Parks and Wildlife

November 11, 2023

Re: Foundation Lutheran Church Subdivision Filing 1

SUBDIVISION PLAT
FOUNDATION LUTHERAN CHURCH
SUBDIVISION FILING NO. 1

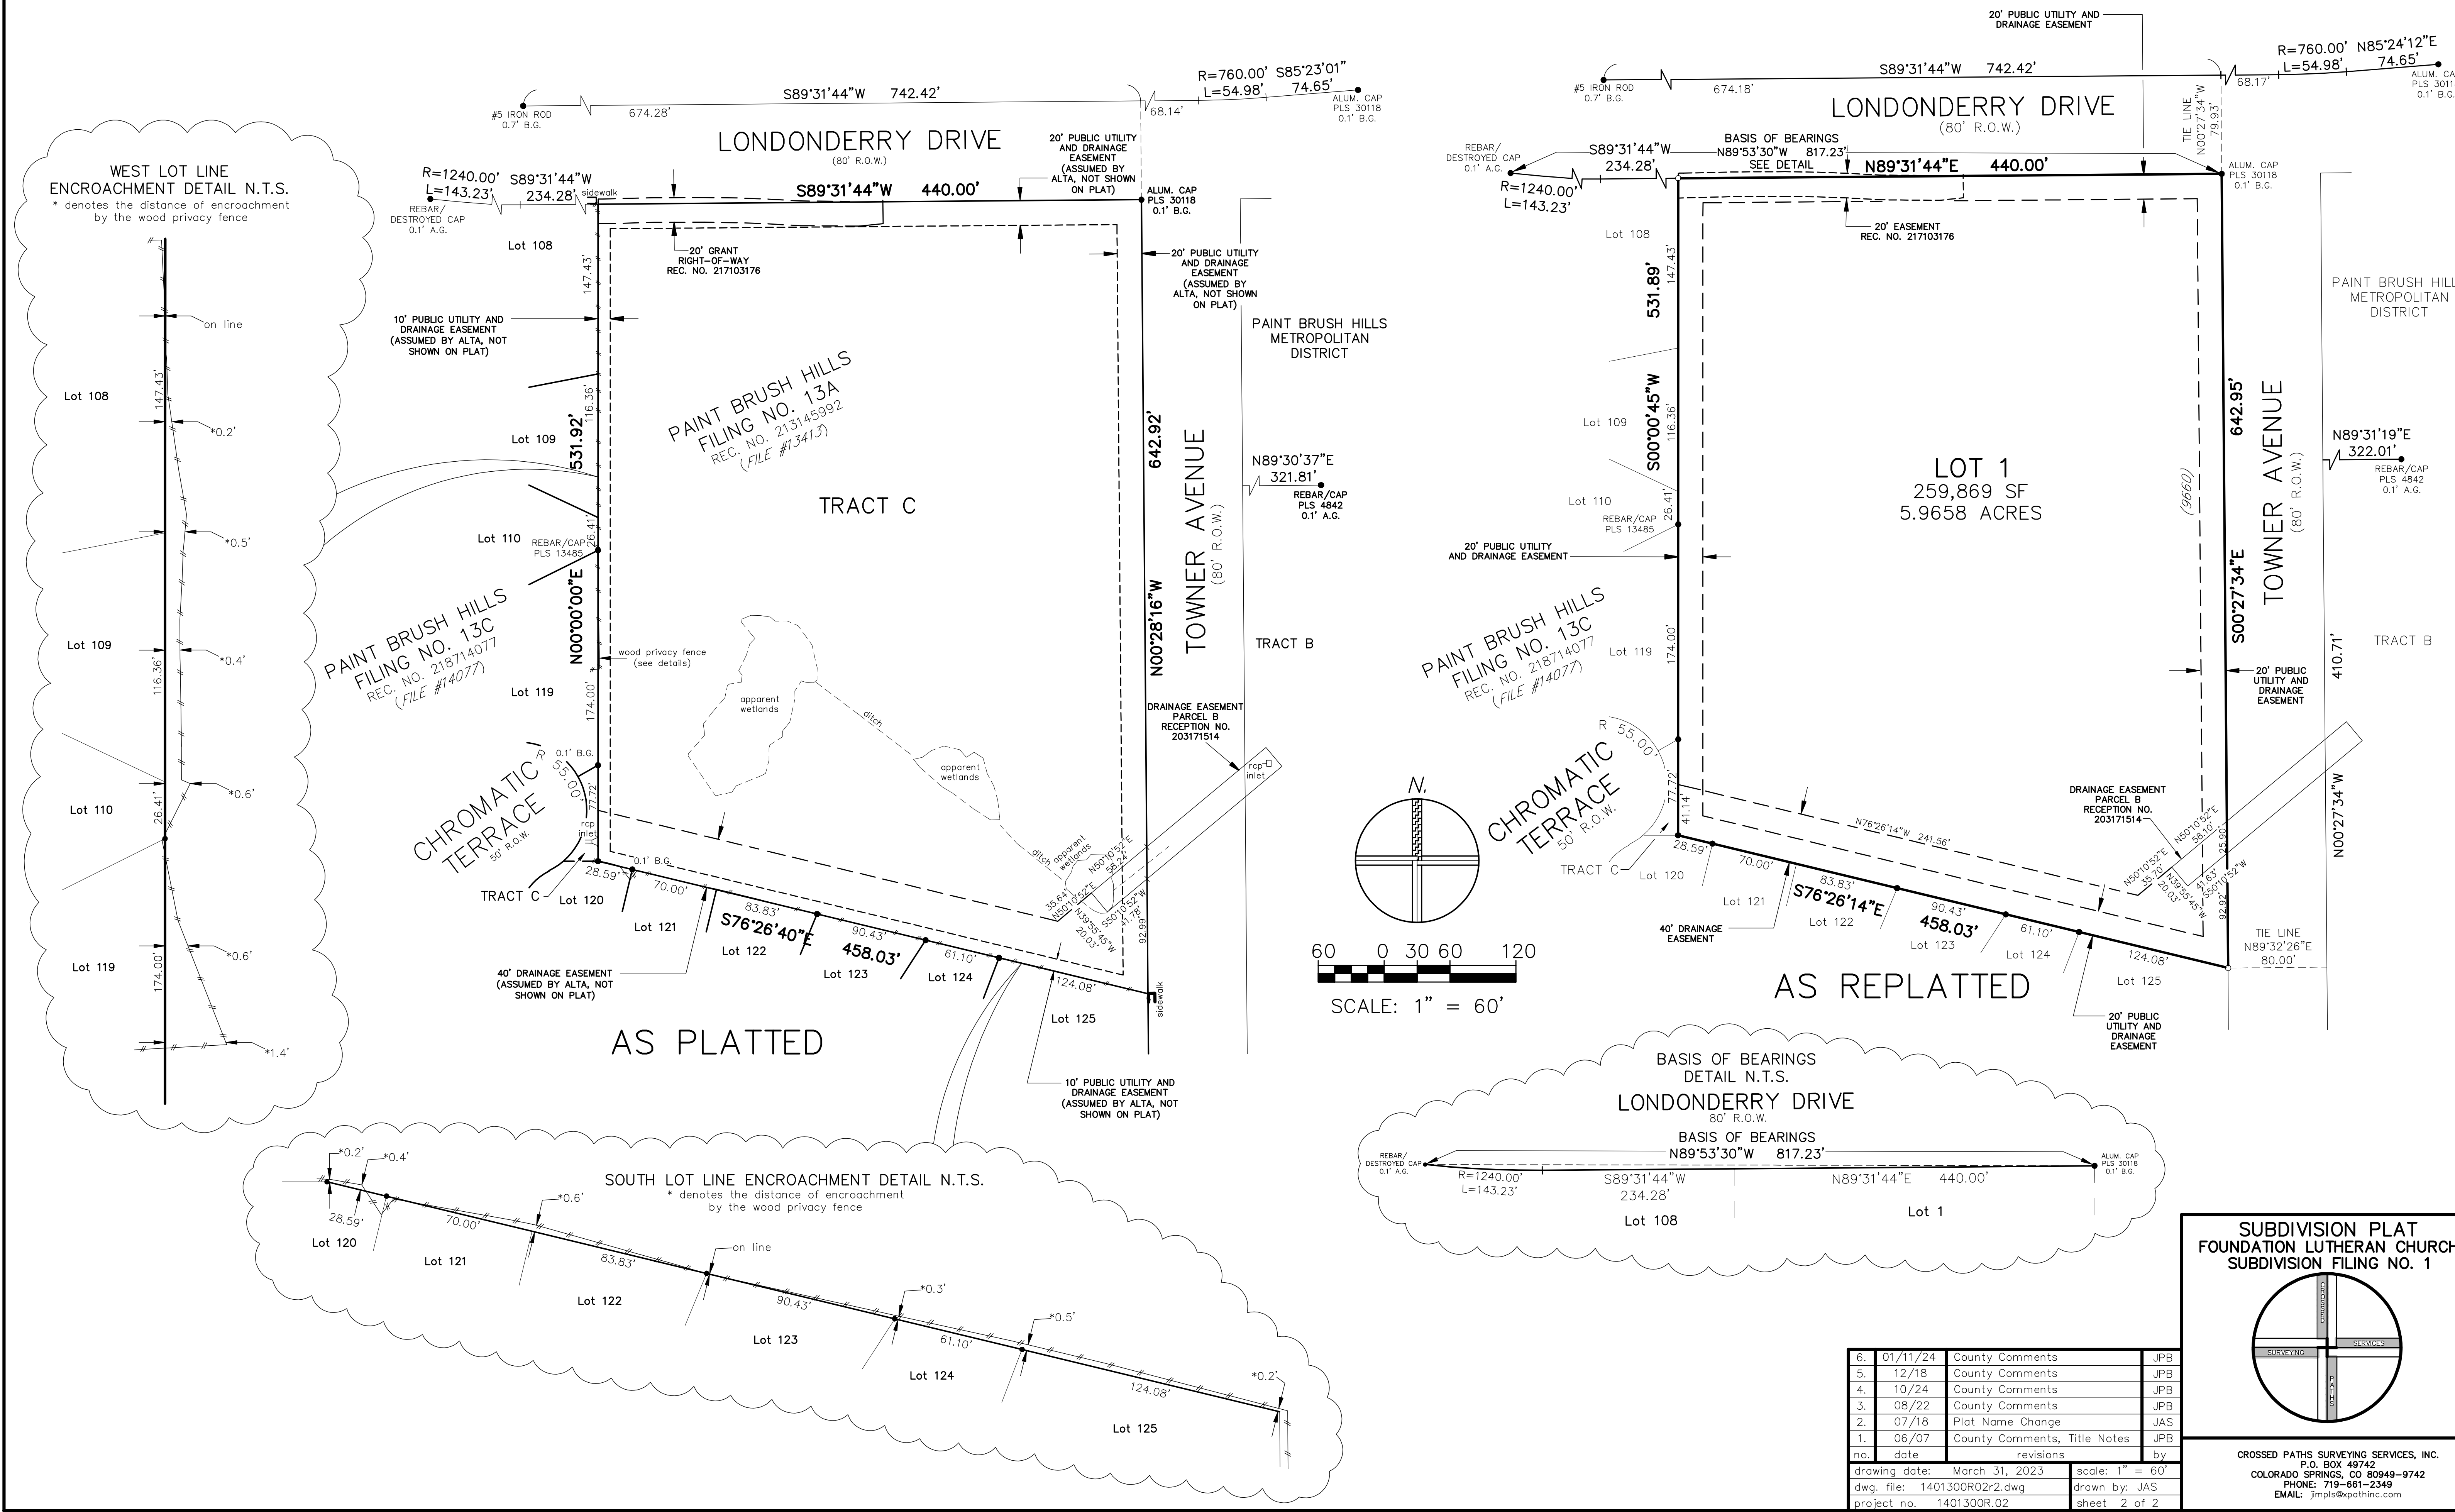
CPW notes that in the Natural Features Report for this project, it is stated that, "This property contains no significant features. The lot is currently vacant and flat with Prairie grasses growing across the 5.97 acres." During a site inspection, CPW found that there is a wetland area on the south side of the property that sustains numerous amphibians, including chorus frogs, western tiger salamanders, and other native amphibian species. Other wetland birds are also present. This area may be small in size, but it is not insignificant.

This wetland may not be jurisdictional, however, CPW recommends consultation with the Army Corps of Engineers to ensure compliance with the Clean Water Act due to the identification of possible jurisdictional wetlands on the site. CPW will comment on specific plans for wetland-related issues as part of that 404 permitting process but there are some general recommendations to be considered during the development of the wetland mitigation plan prepared as part of section 404 permitting.

CPW recommends no disturbance to the wetland area.
